Applicant: Mr Robert Yates

Proposal: Non material amendment to 19/02112/F - the existing garage door will be removed and replaced by a solid brick wall

Expiry Date: 10 February 2020

FRONT ELEVATION

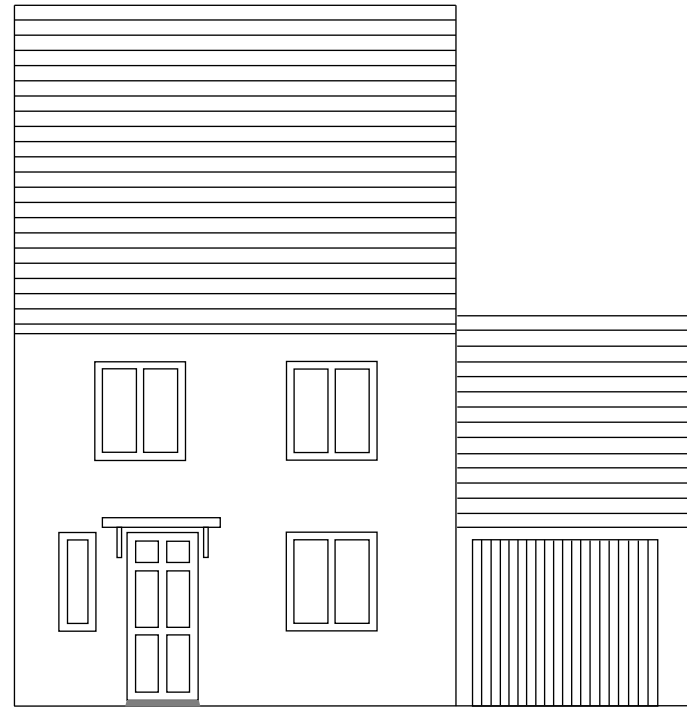
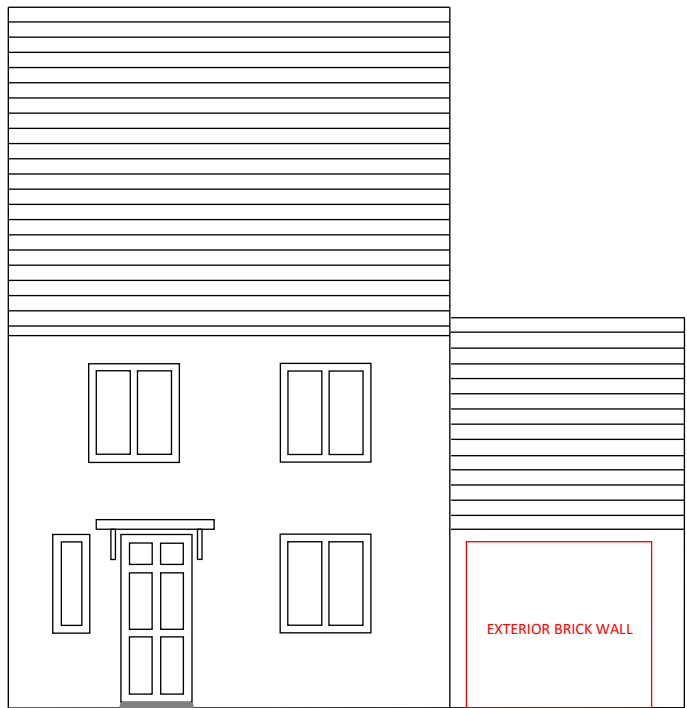
- 5.4. The proposed changes would not result in an increase in the footprint of the garage or the addition of any further openings and therefore there would be no additional impact on neighbour amenity or parking provision. The garage door on the front of the property would be removed which would be visible from the public domain on Wetherby Road which would have an impact on the streetscene of the area. While this is the case, the materials used to fill the wall in would match those seen on the existing building and therefore would retain the character of the original house. It is therefore not considered there would be any negative impacts on the surrounding area.
